From: Paul Troop <pault@gclaw.co.uk>
Sent: 02 January 2024 06:27
To: Rebekah Morgan; Planning; White, Joy - Oxfordshire County Council; JacquiCox (OCC)
Cc: chair@bicesterbug.org
Subject: 23/03438/REM (Bicester Motion)

BBUG have reviewed this application and have a number of comments from the perspective of cycling:

# BICESTER MOTION - INNOVATION QUARTER LANDSCAPE MASTERPLAN

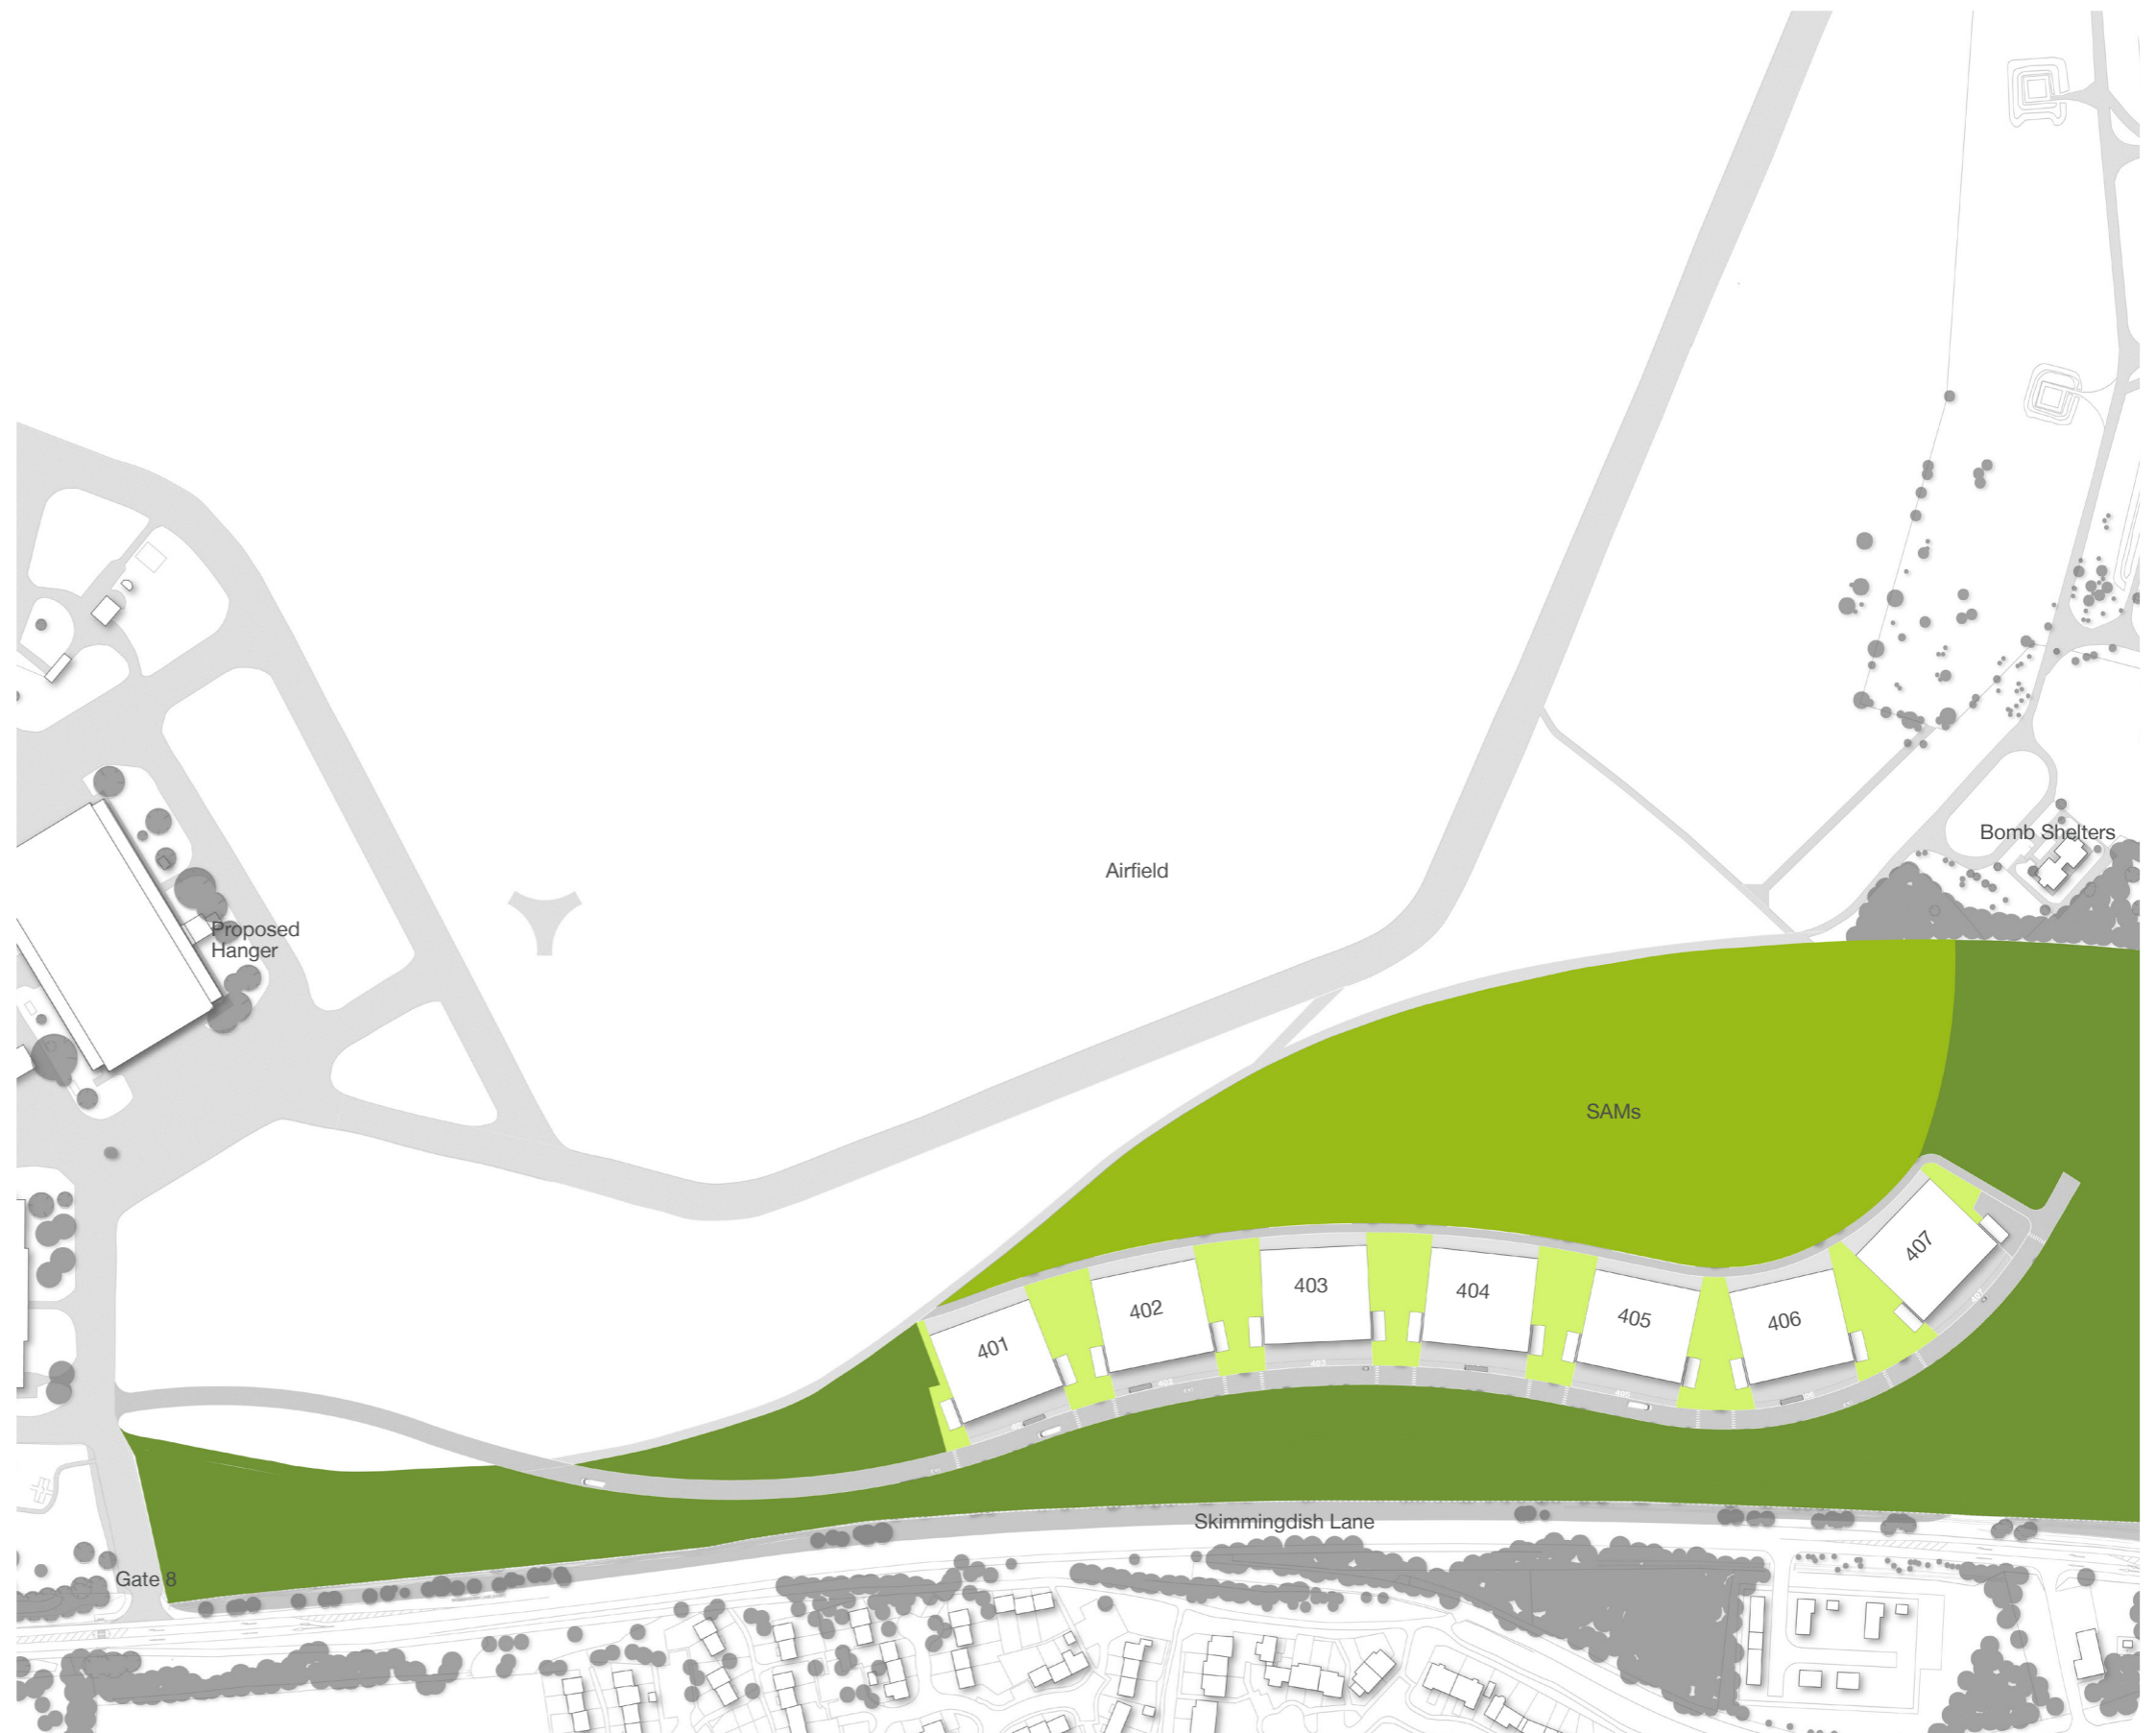
- The width and treatment for the pedestrian / cycle paths are not clear. Given the probability of conflict between these different modes, it is imperative that adequate width is provided so that bike users can steer a reasonable berth around more vulnerable pedestrians.

PARKING /ARRIVAL STRATEGY

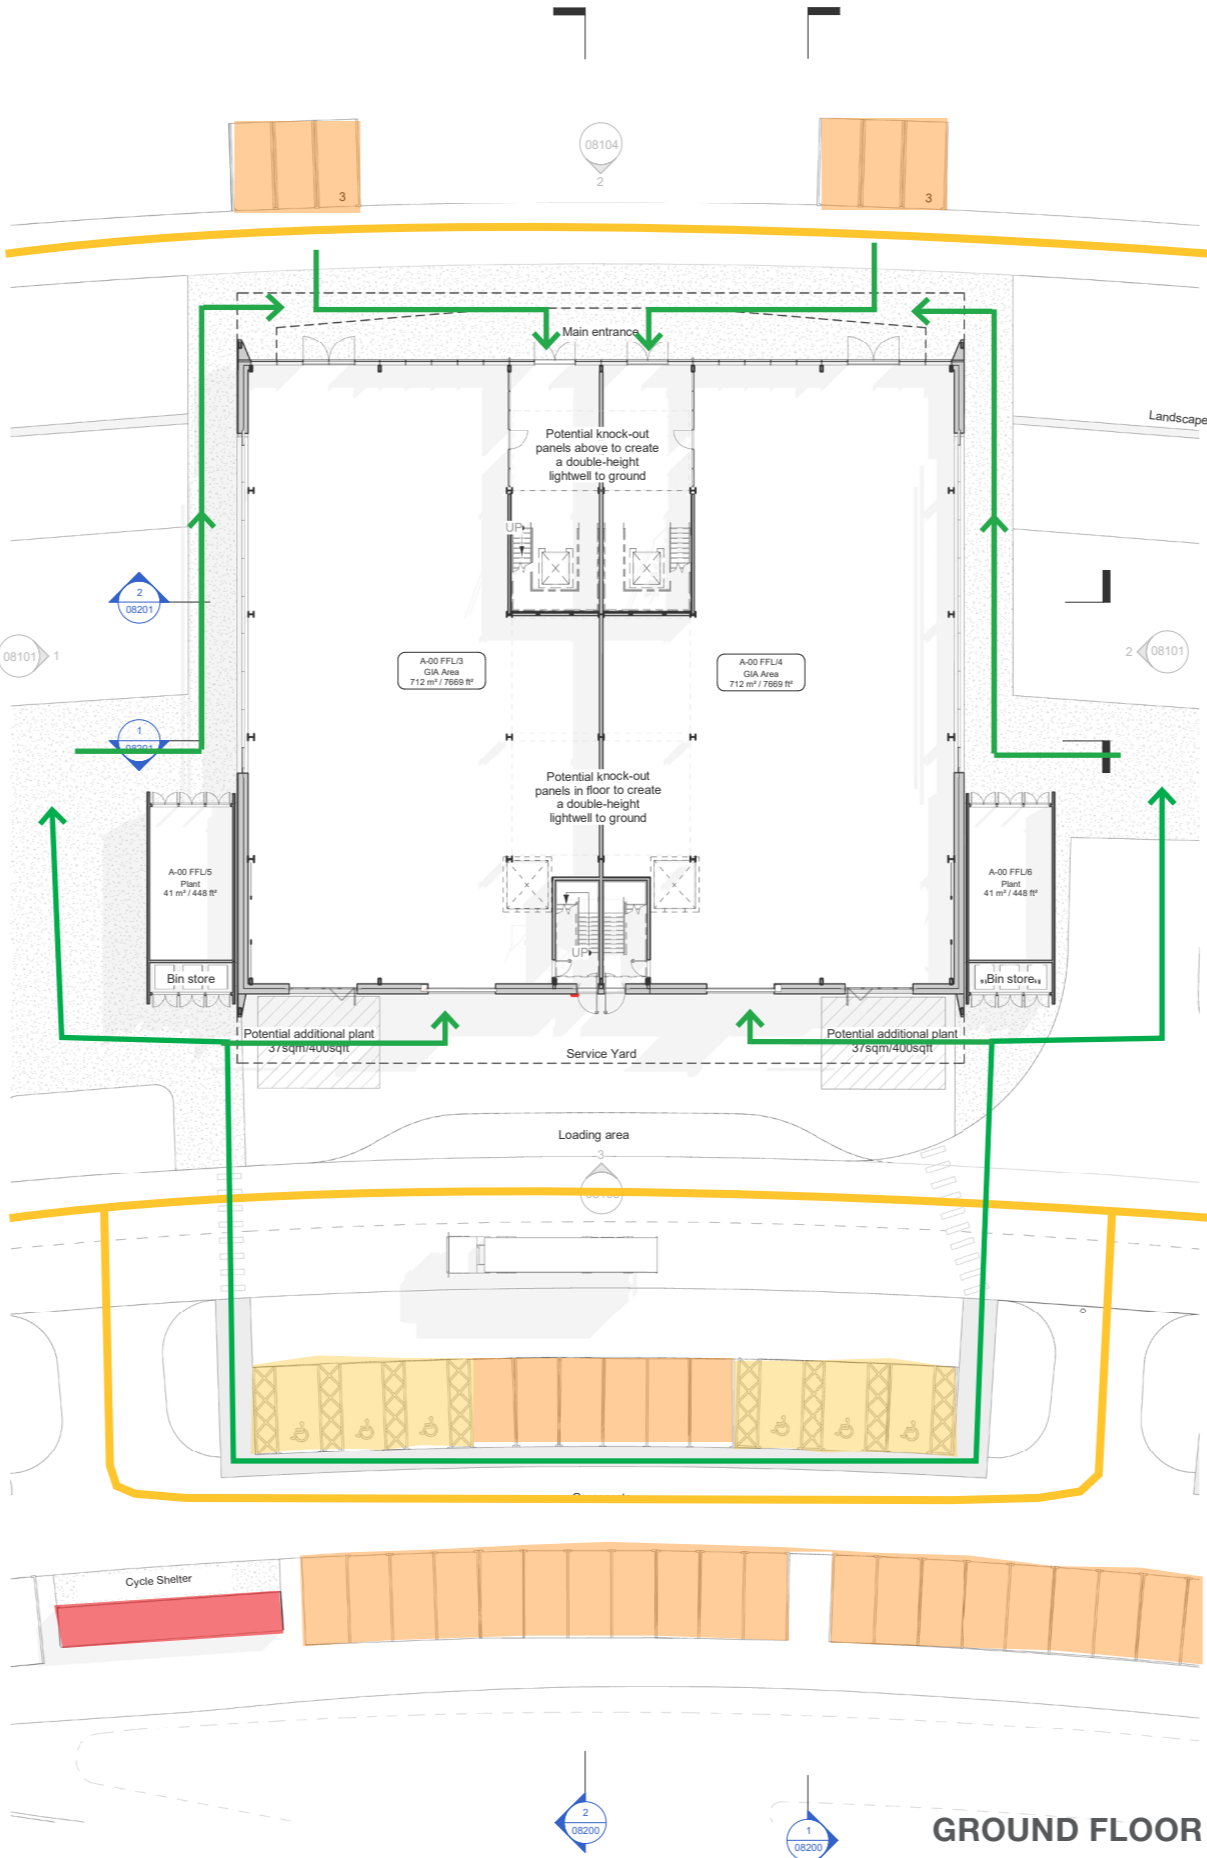
- The location of the bicycle parking is some distance from some of the buildings and does not offer convenience or good passive surveillance. With the increasing use of electric bikes and their corresponding increased value, it would be advisable to locate the bike parking near to the entrance of each unit.

- At present the bike parking envisages double stacked parking. This saves space, but is very inconvenient for most users. Given the apparent availability of space, single level 'Shelved' stands would be much more preferable.

- The bike parking foresees only standard two-wheeled bikes. Other users of adapted, disability, or non-standard bikes such as cargo bikes or tricycles should also be catered for. This may require some wider bays for users.
